From: Charlotte Watkins
Sent: 05 December 2023 15:11
To: Suzanne Taylor
Subject: RE: Planning notification for application reference: 23/00207/DISC

The actual metric has now been submitted. Whilst I appreciate this is not yet at a detailed design stage there are issues with the metric which should be addressed with comment from the applicant as a minimum.

Project Himley Village, Bicester  
 Drawing Title Habitat Features 2023  
 Scale As Shown (Approximate)  
 Drawing No. 15525/P03b  
 Date December 2023  
 Checked JS/RC

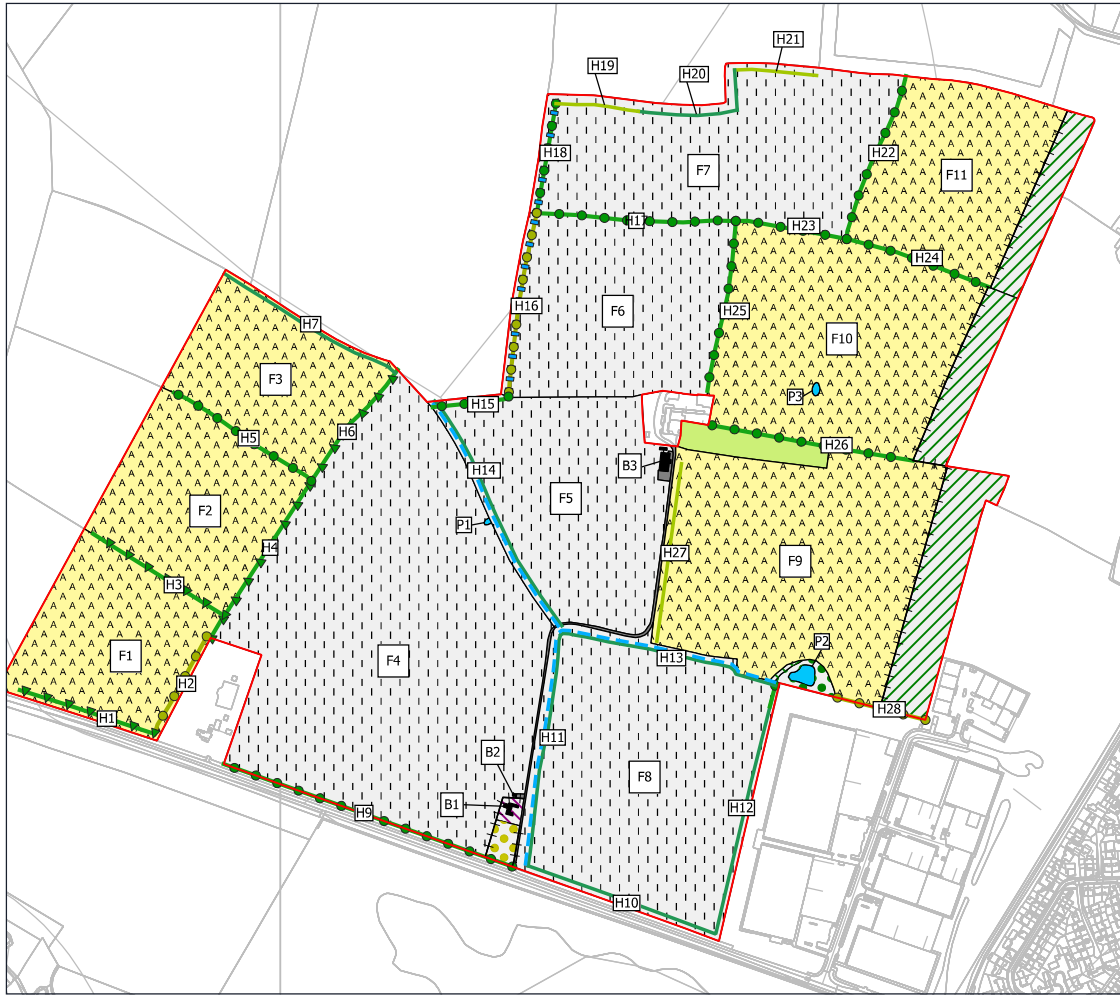
- The loss of hedgerows of high distinctiveness have not been replaced with hedgerows of the same distinctiveness (or higher) which they must under the trading rules. The trading rules for this linear habitat are not met therefore. Sometimes this may be permitted if there are exceptional circumstances but it has not been justified here.

- There are several ditches on site some of which are said to be wet. Where ditches are on site the watercourse section of the metric must be used and a net gain achieved in this linear habitat also. Here they have stated there are no ditches on site by leaving the watercourse part blank and there is no justification of exceptional reasons why this has been done within the biodiversity strategy. They have not demonstrated that a net gain is achievable here therefore nor shown the baseline value of these wet features - which should be included in this biodiversity strategy.

Hedgerows in NW Bicester must have (under the masterplan biodiversity strategy) 10m buffers each side, which should be 'largely diverse grassland'. The proposals here appear to be for hedgerows to be buffered each side with mixed scrub. This may have some ecological benefits but may also make it difficult to manage hedgerows and the impact of shading on hedgerow condition should be considered at the detailed stage.
